CITY OF ALBUQUERQUE
PLANNING DEPARTMENT
DEVELOPMENT REVIEW BOARD

December 4, 2013

Project# 1009881

13DRB-70744 MAJOR – SITE DEVELOPMENT PLAN FOR SUBDIVISION

EAGLE CREST
SUBDIVISION

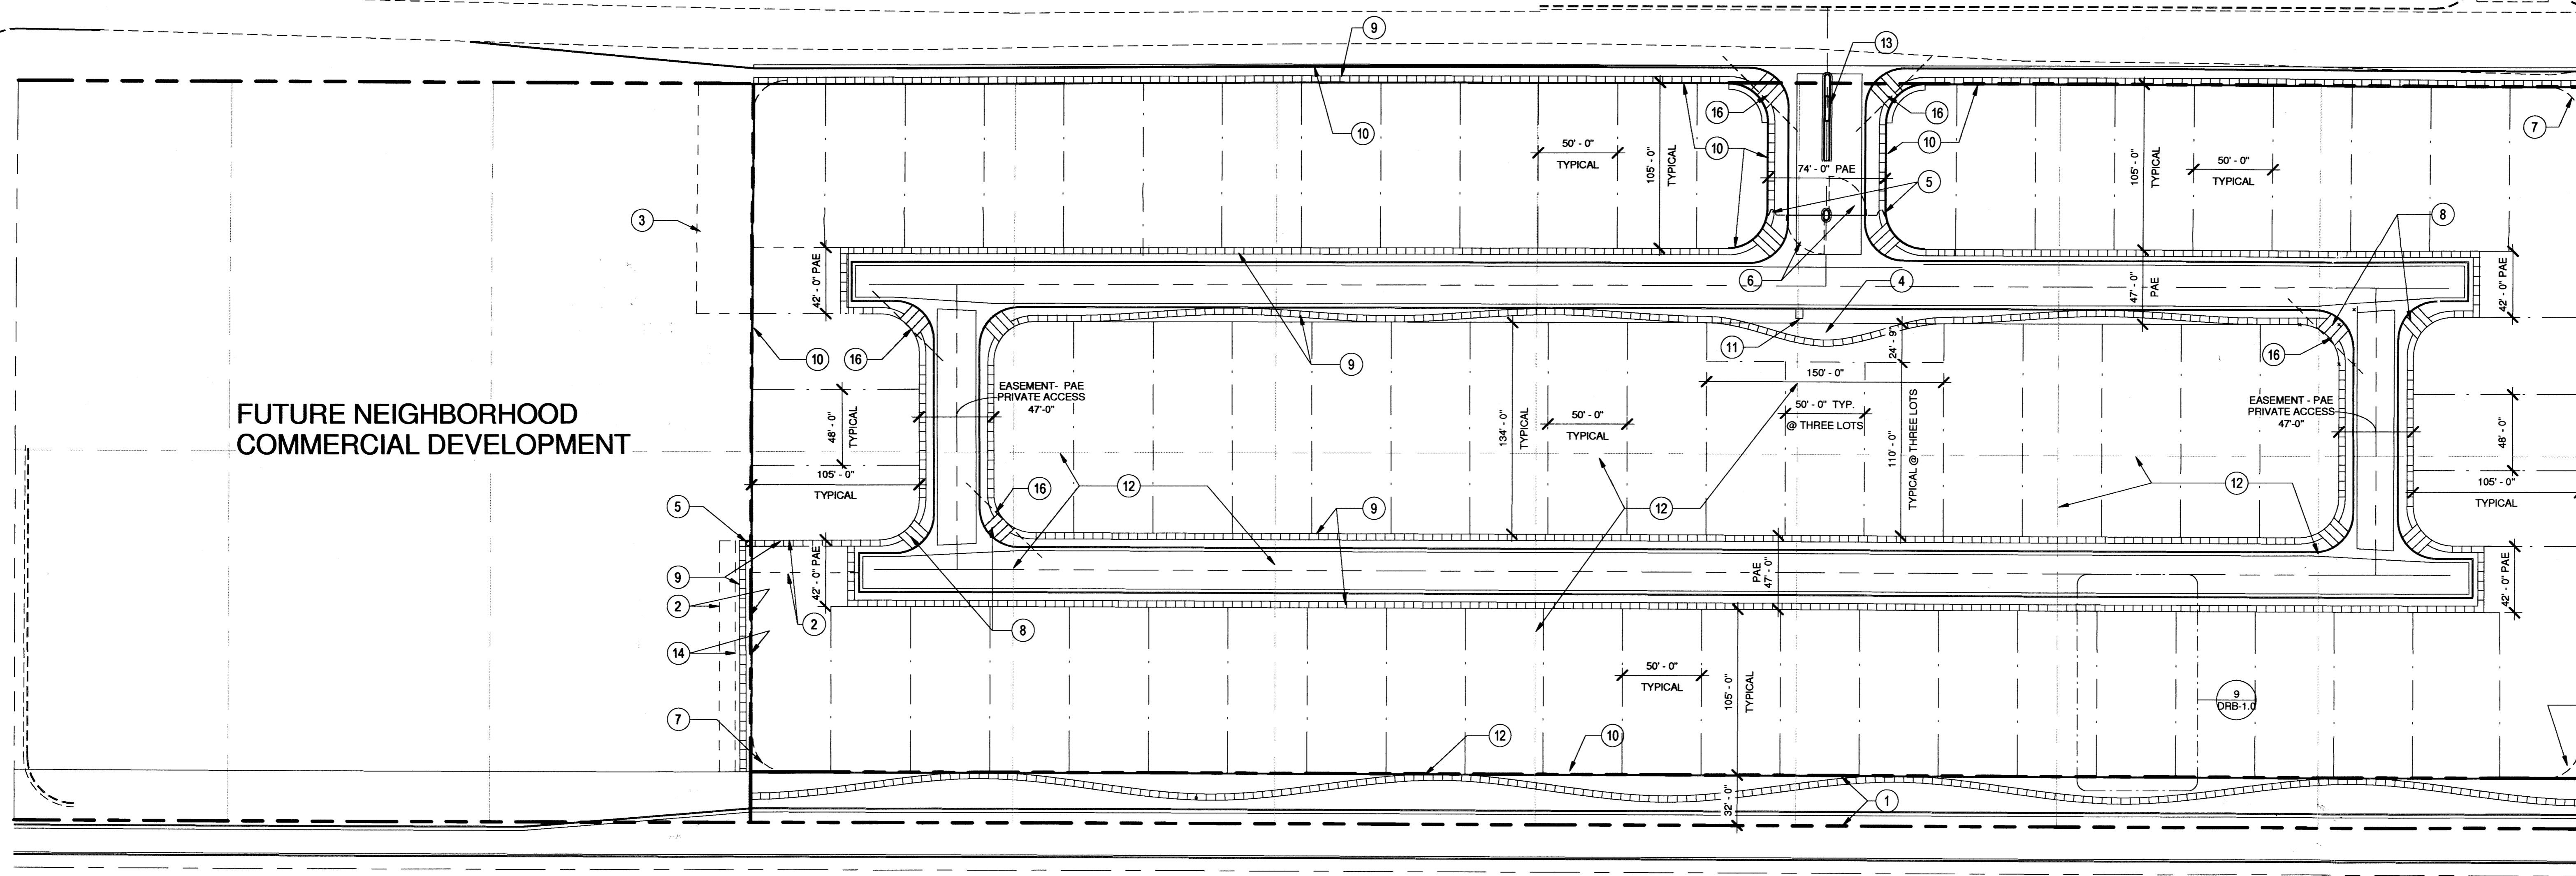
Provide an exhibit showing the location of sidewalk and defining the distance from back of curb to the property line for Oakland and Alameda. Right of way dedication may be required. A note indicates that the roadways are "Easement – PAE Private Access." What does PAE indicate?

Provide a cross section for the proposed private roadway(s).

Show all easements, existing and proposed. Provide recording information.

Street names must be shown on the Site Plan for Subdivision.

A pedestrian connection is shown on the future neighborhood development. Provide additional information.

Refer to comments from Zoning Enforcement plus any public hearing comments regarding proposed site plan. The CENTRAL LANDSCAPE PARK needs to be part of the private access easement (it appears to be a separate parcel).
